Sheridan Heights 10.01.07

I've completed the review and have the following questions/ comments or need the following info:

Mike Nugent
Consulting Plans Examiner
City of Portland

SHEET TITLE:
FOURTH
FLOOR
MECHANICAL
PLAN

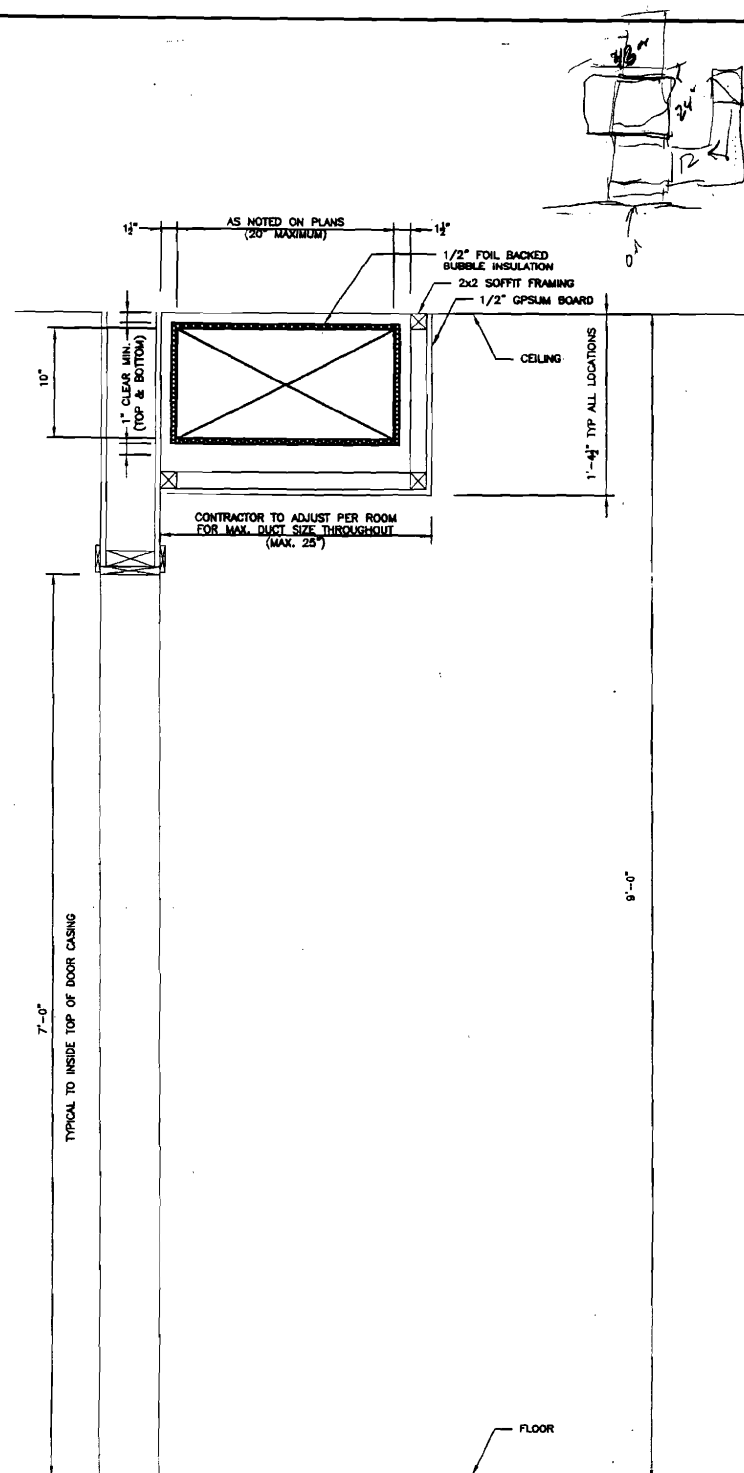
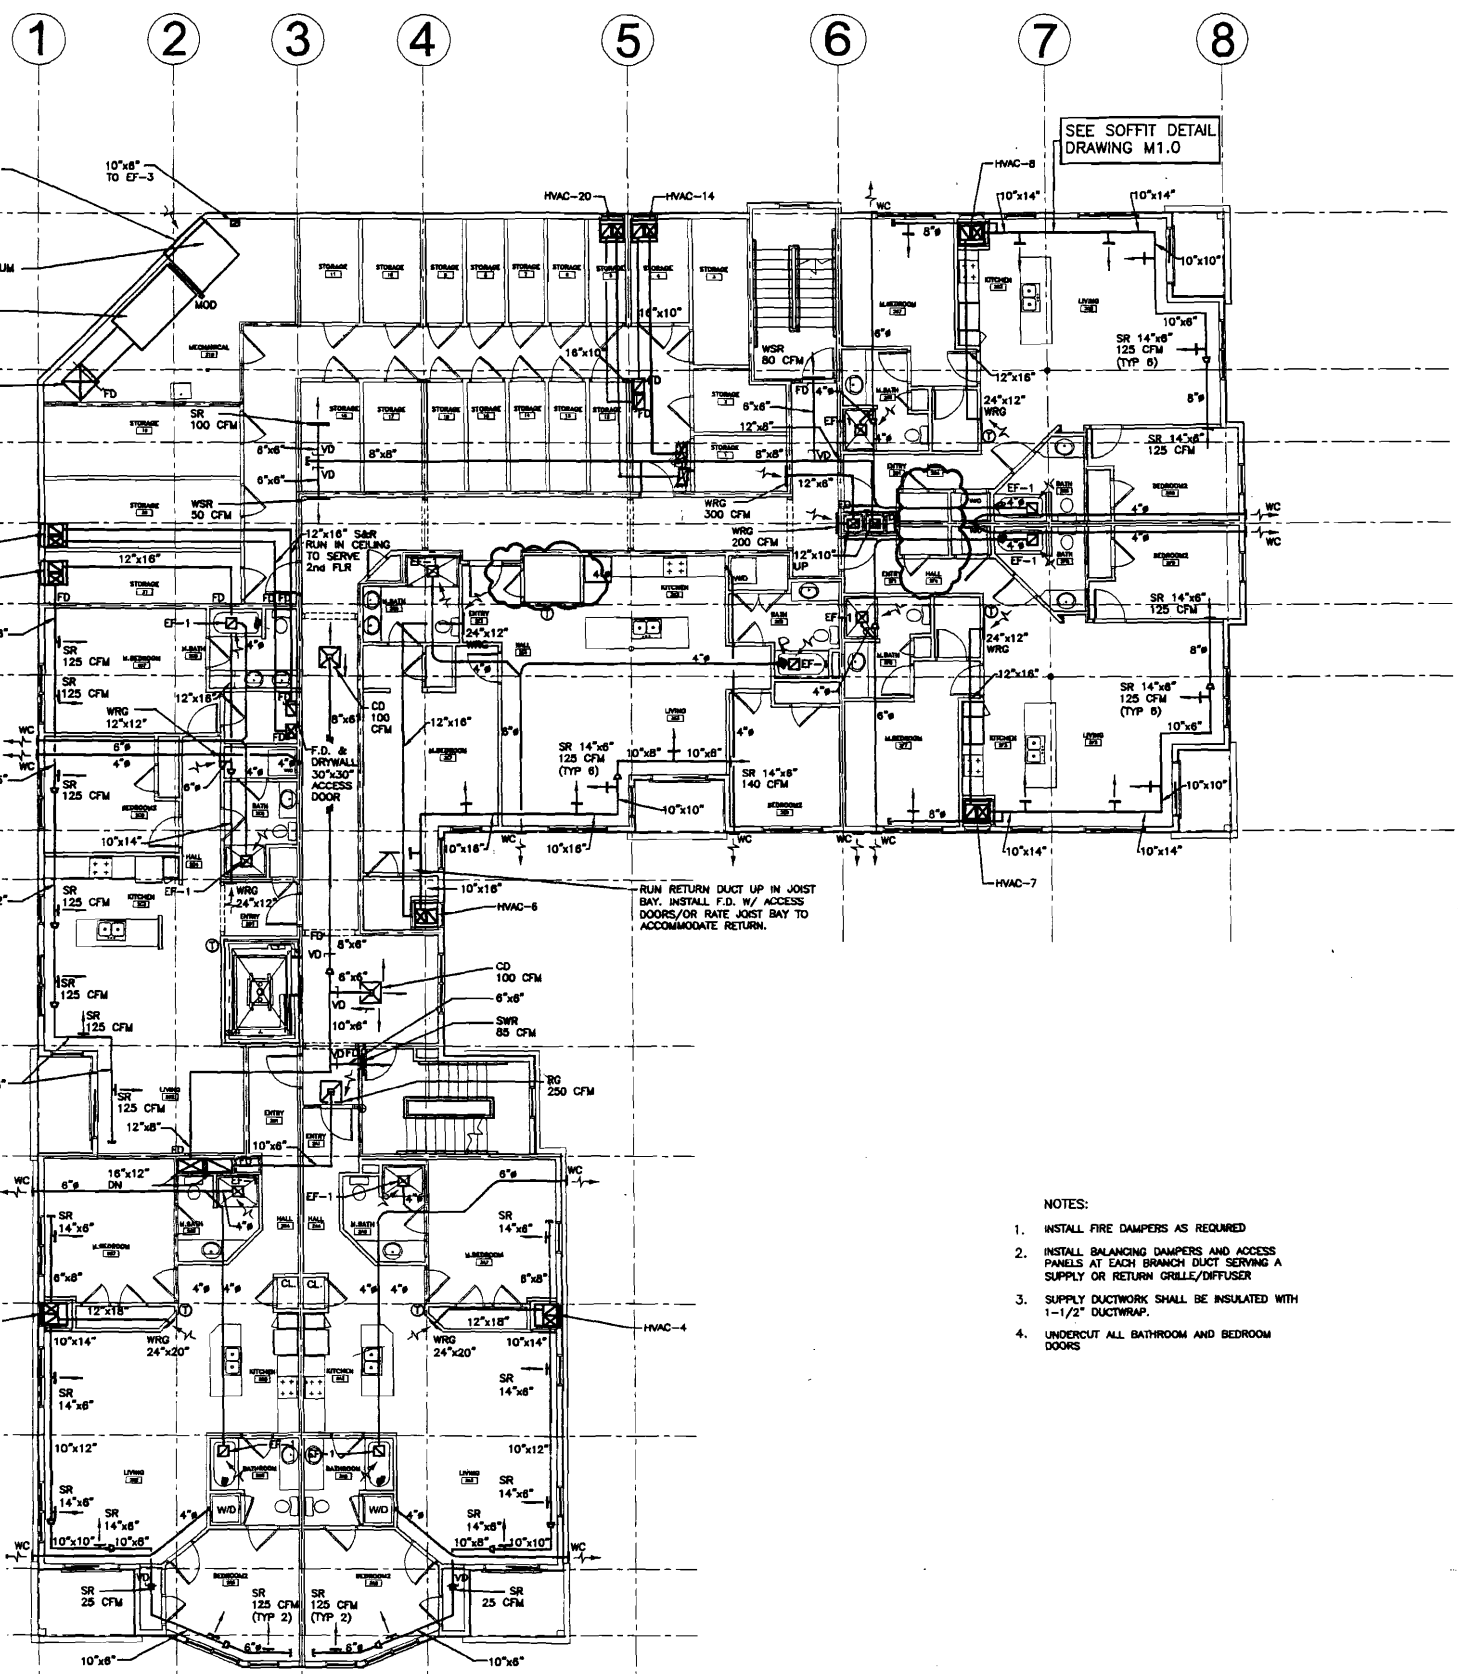
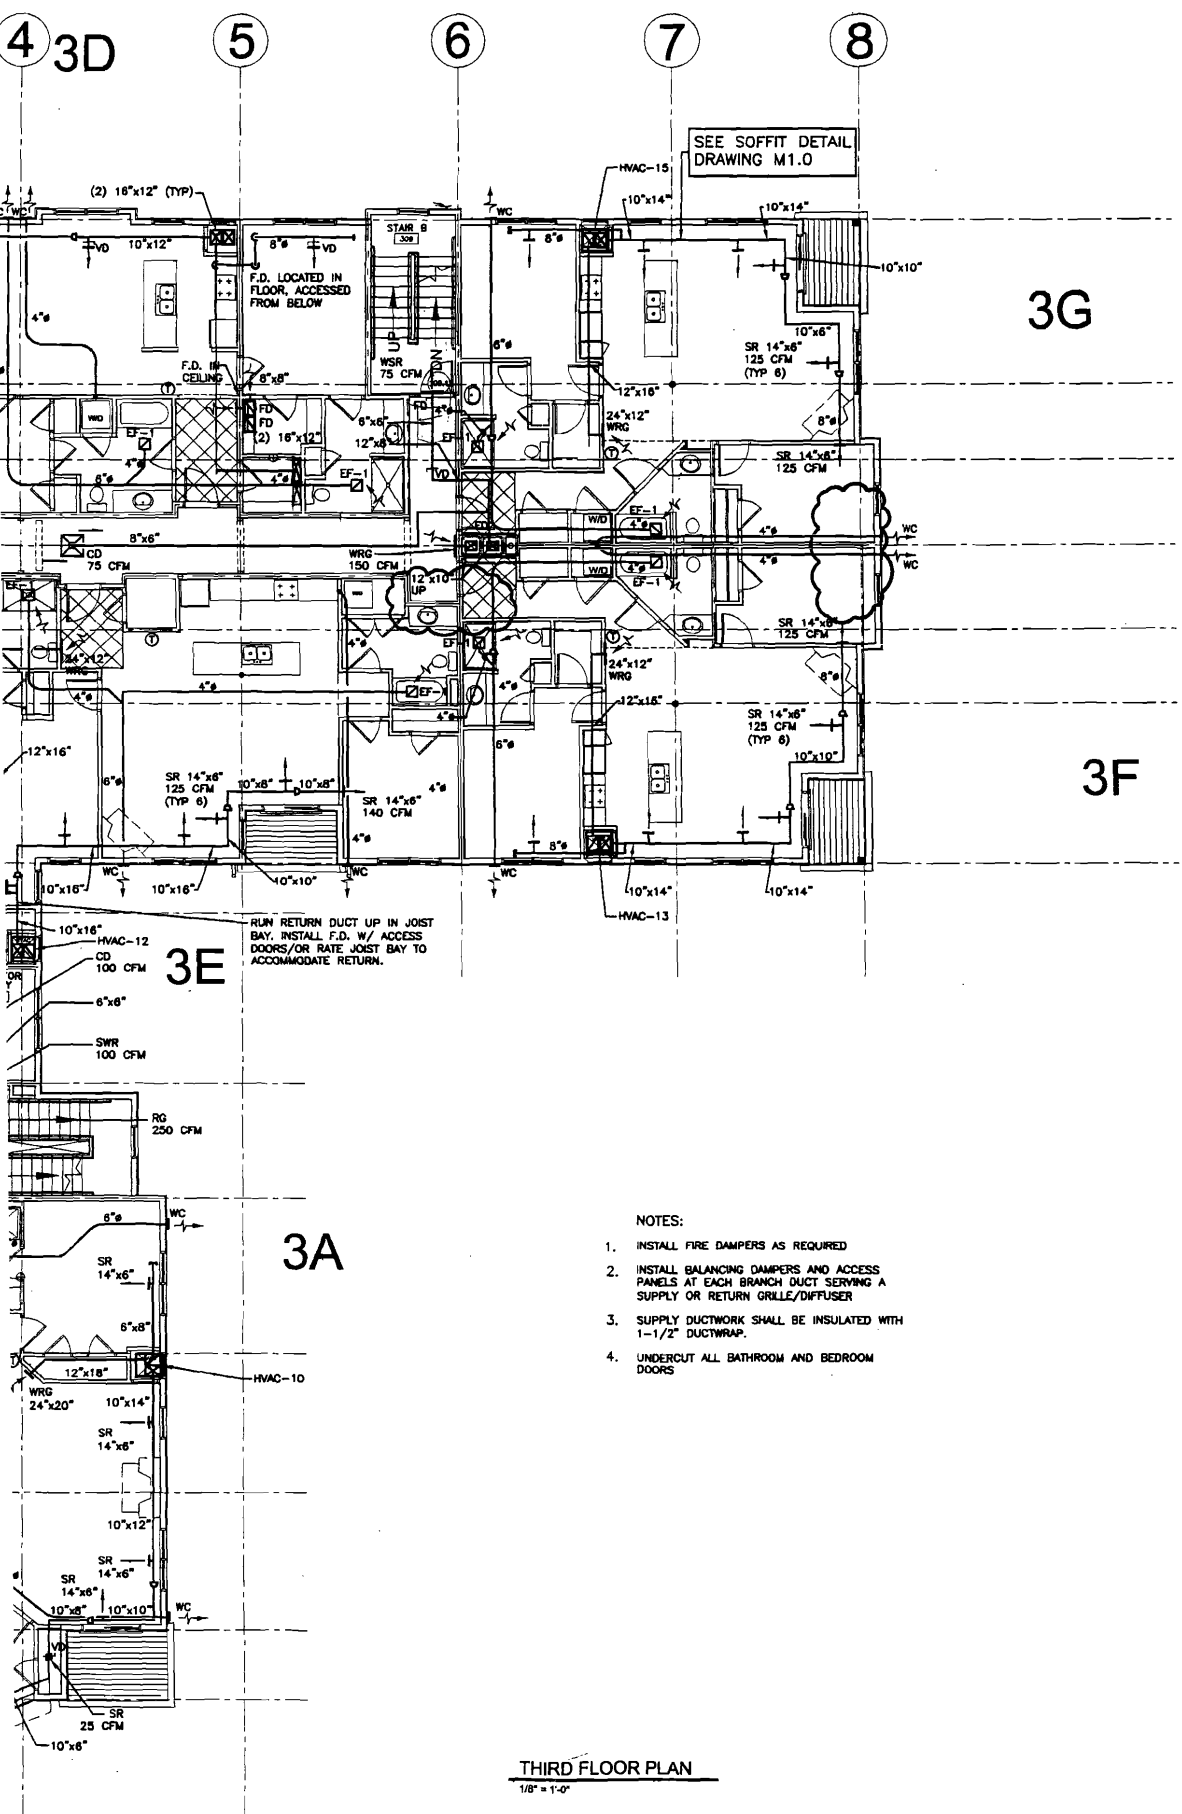
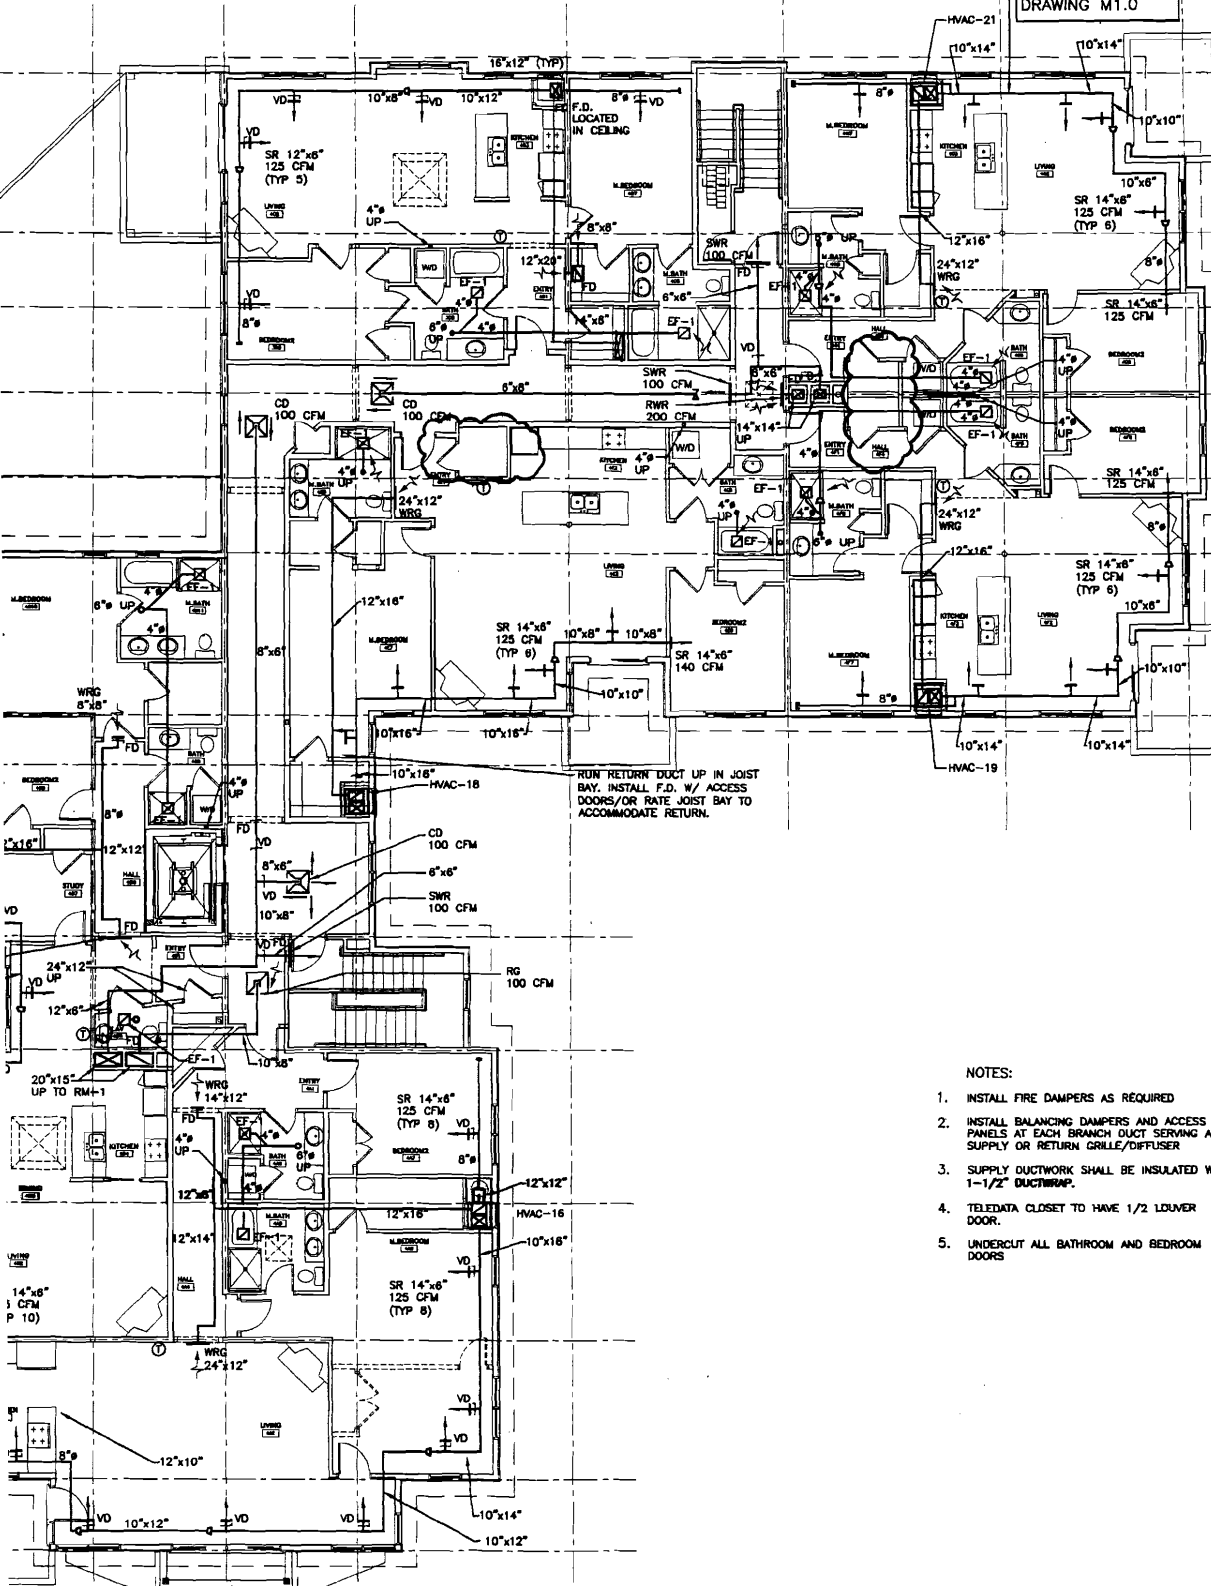
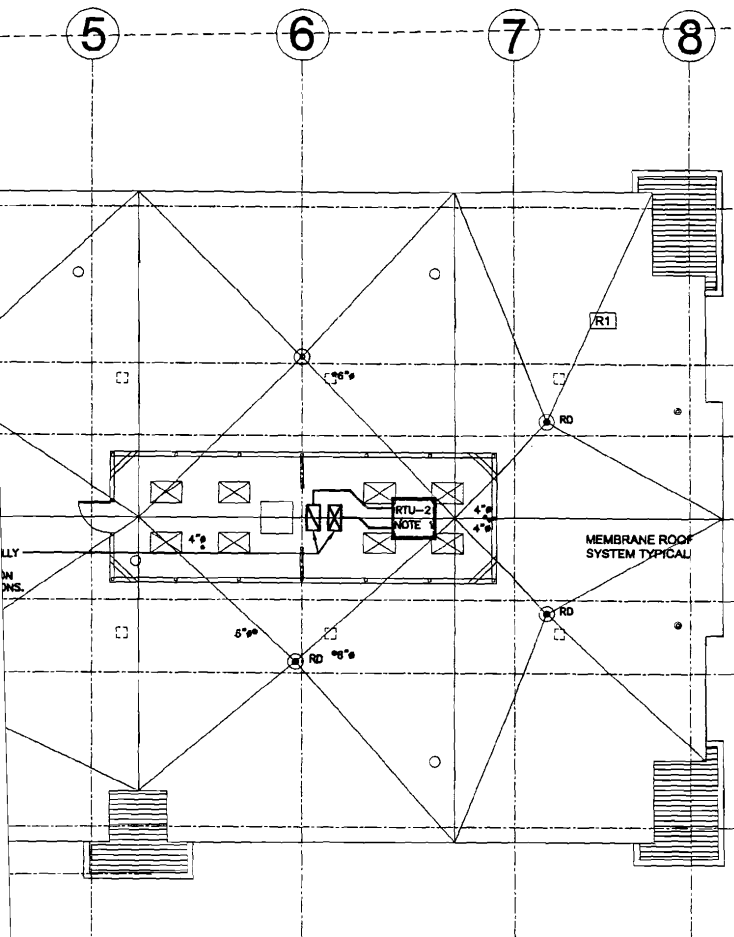
14) The "M" series plans are not stamped and provide little detail, no damper locations

Greg Shinberg will resubmit Mechanical Drawings.

Drawing file: PDF070981 / Sheridan Heights - Area of unprotected openings - 2007.08.14.pdf

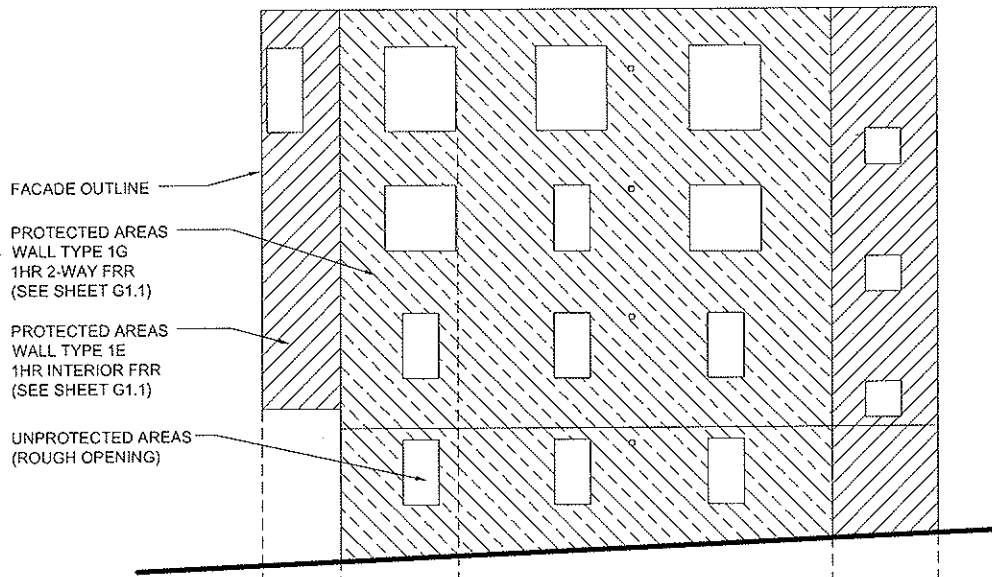
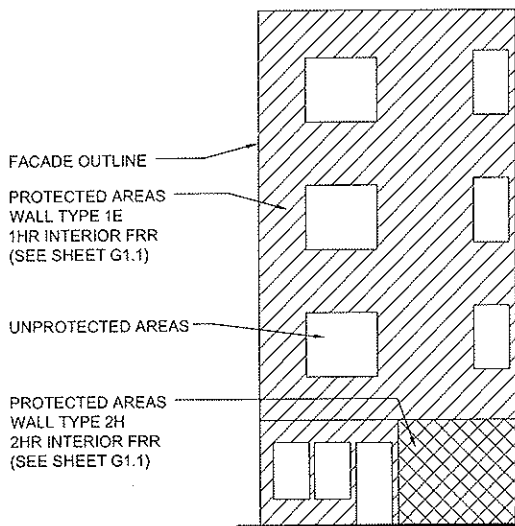
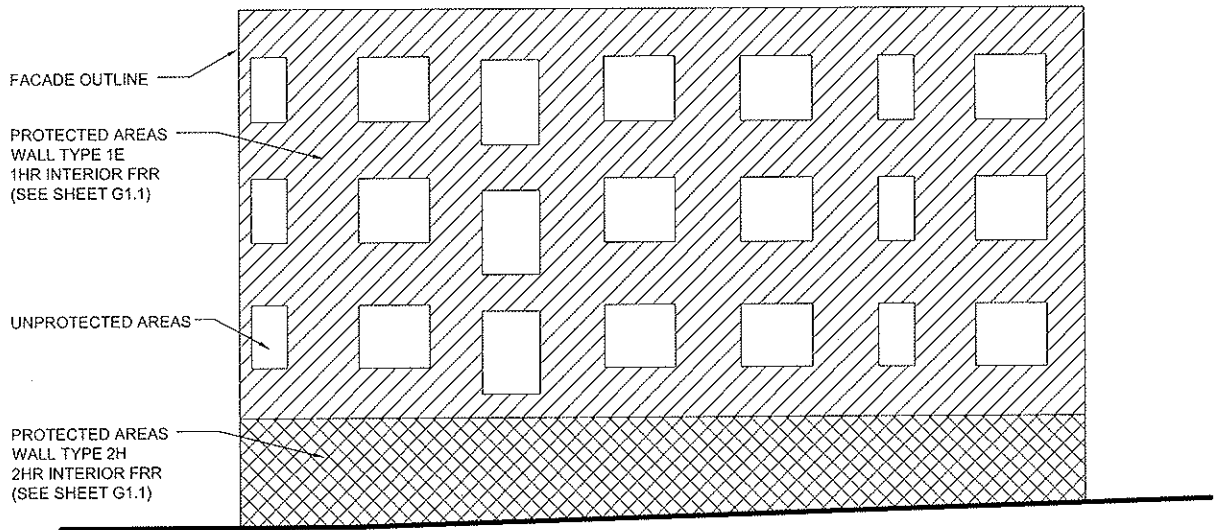
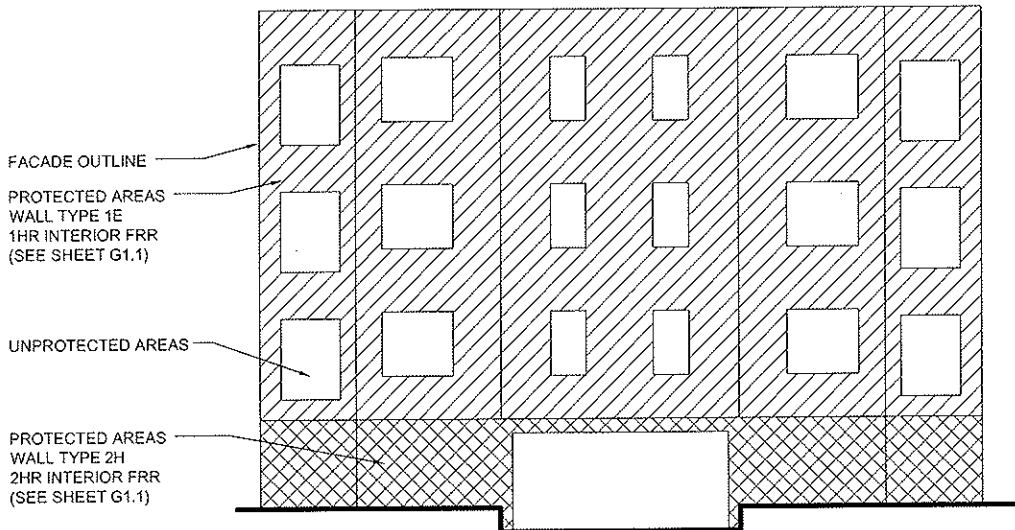
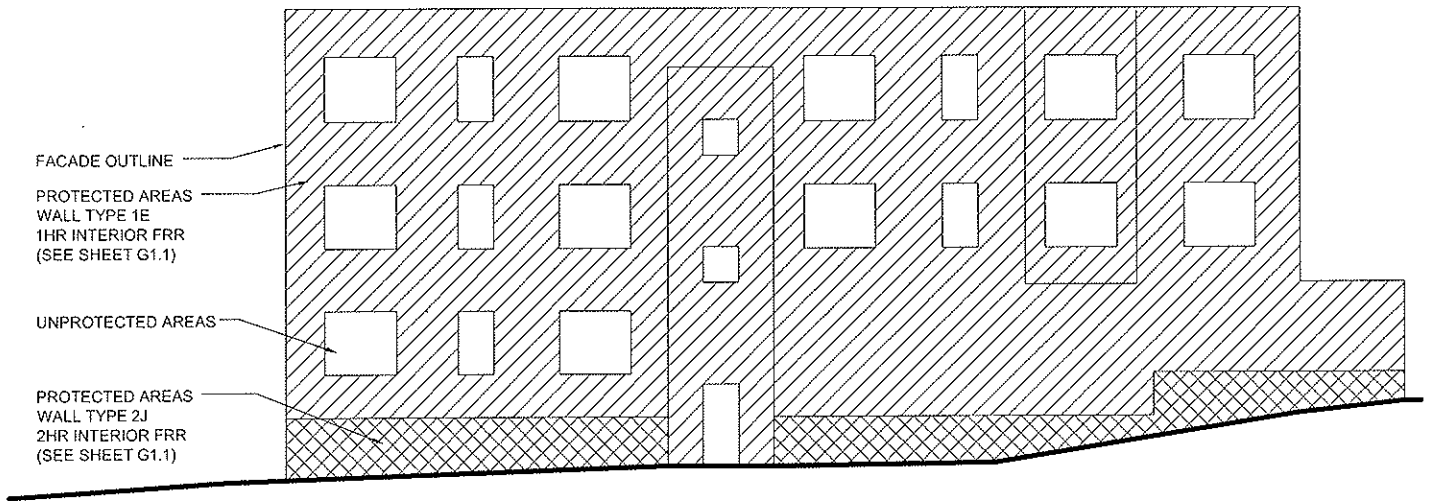
7) We received the North elevation request for waiver for the % of unprotected openings, you failed to identify the other elevations and

their percentages, It looks like they all have limitations as well, please provide all elevations and their percentages

See attached PDF; this was submitted to Inspections on 8.14.07
